**From:** Keith Curtis <keith@pprbd.org>  
**Sent:** Monday, December 6, 2021 11:22 AM  
**To:** johngreen@elpasoco.com  
**Cc:** Dennis Hathcock; Joan Hathcock  
**Subject:** RE: MINOR SUBDIVISION file no is 21-131

In reviewing the subject subdivision I find that it is exposed the A zone Floodplain.

DOUBLE SPUR RANCH MINOR SUBDIVISION FINAL PLAT

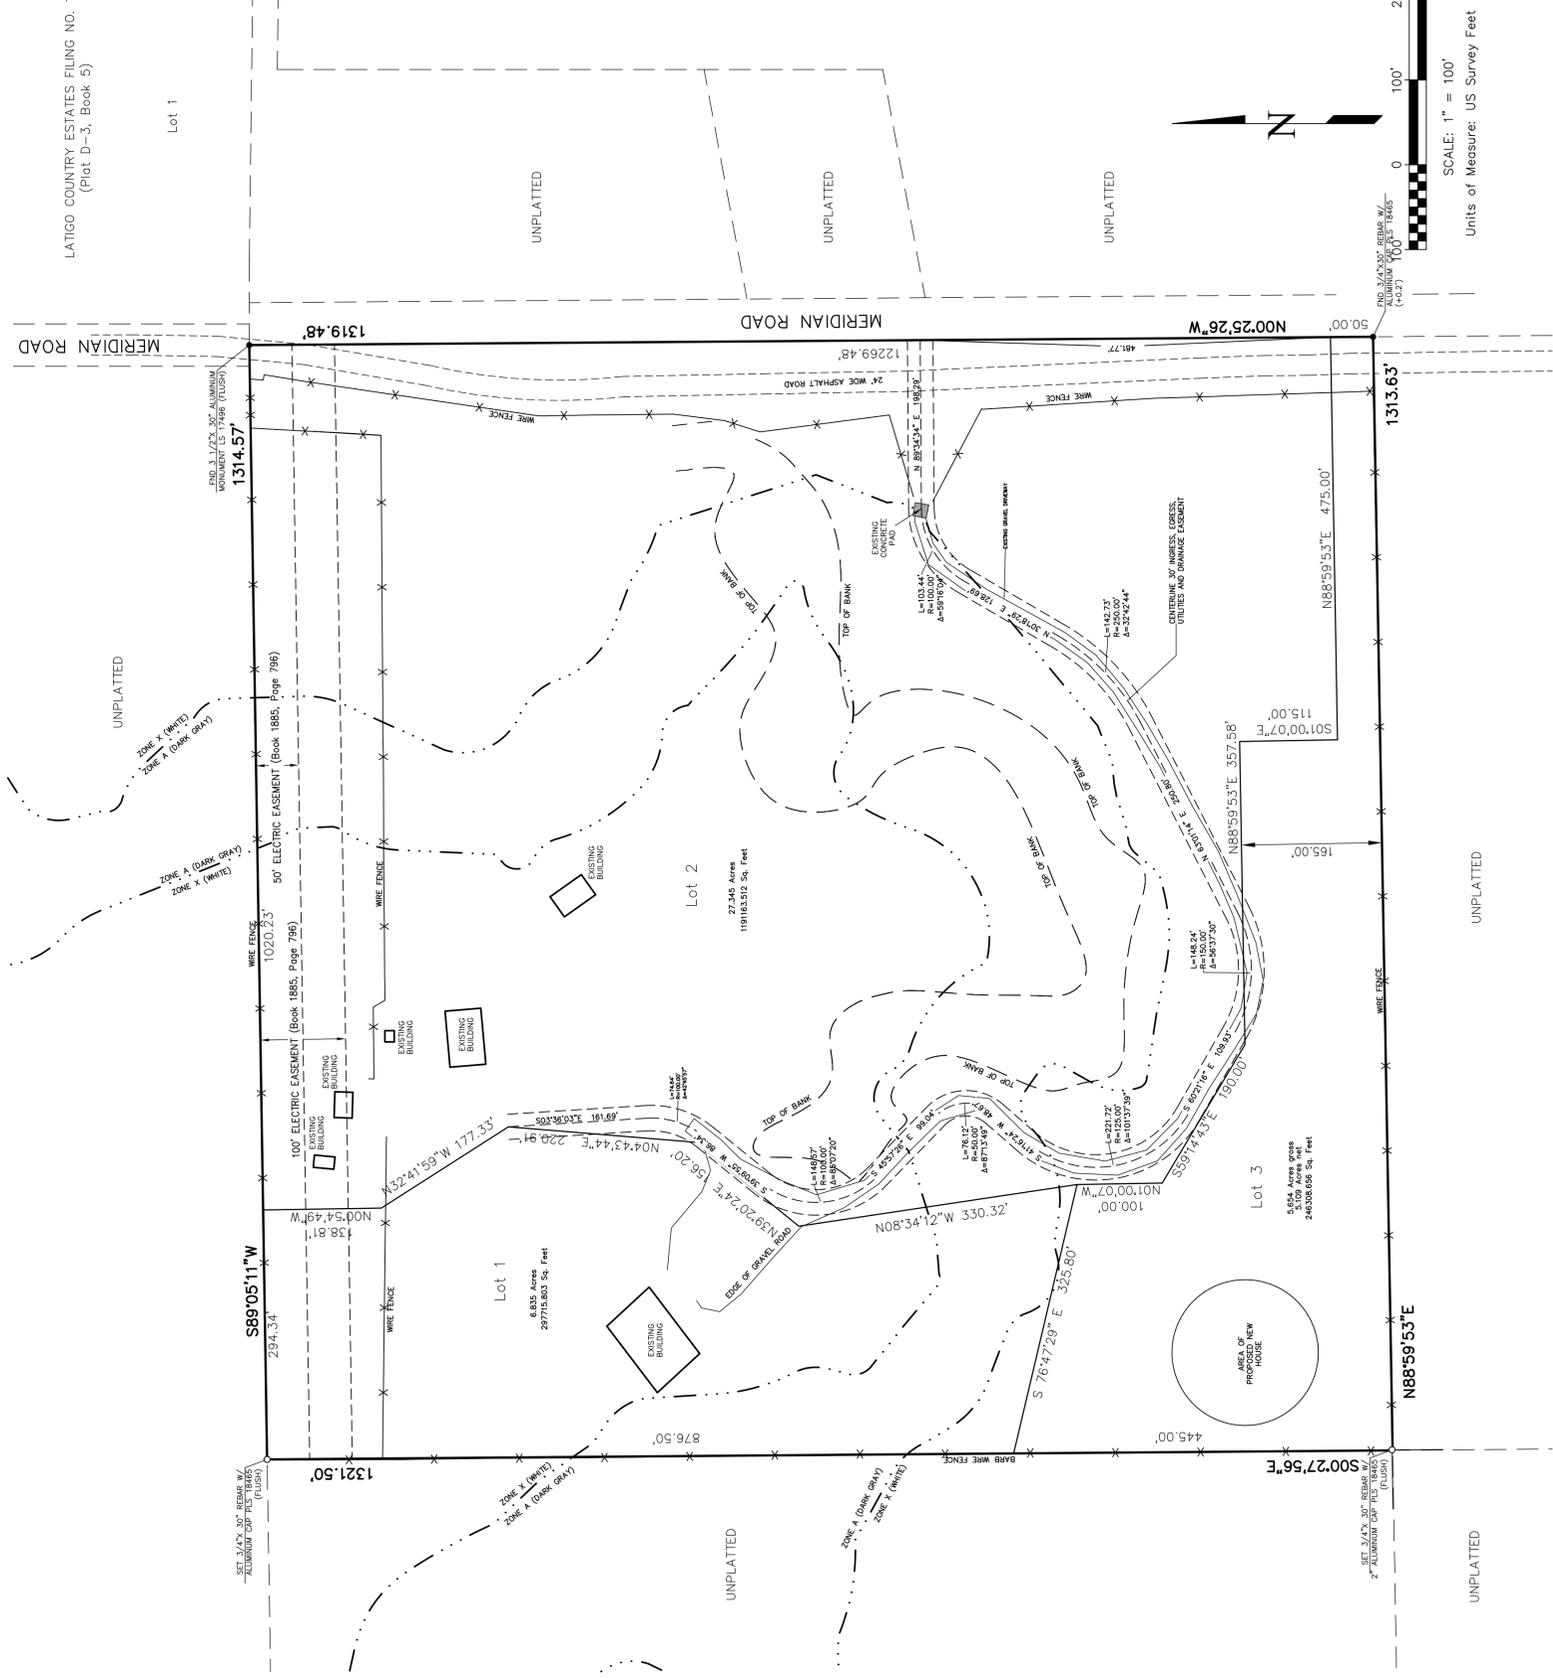
Subdivision requirements specify that the A zone should be studied and BFE shown on the plat.

However this area is already being restudied and remapped by FEMA as part of the Statewide risk map program.

FEMA has set the precedence locally that they will not process LOMR requests if the area is already under restudy because of duplicative effort on their part.

I therefor recommend that this subdivision proceed as per normal waiving the BFE and restudy requirements while showing the current effective floodplain limits and specifying those areas no build no storage of materials.
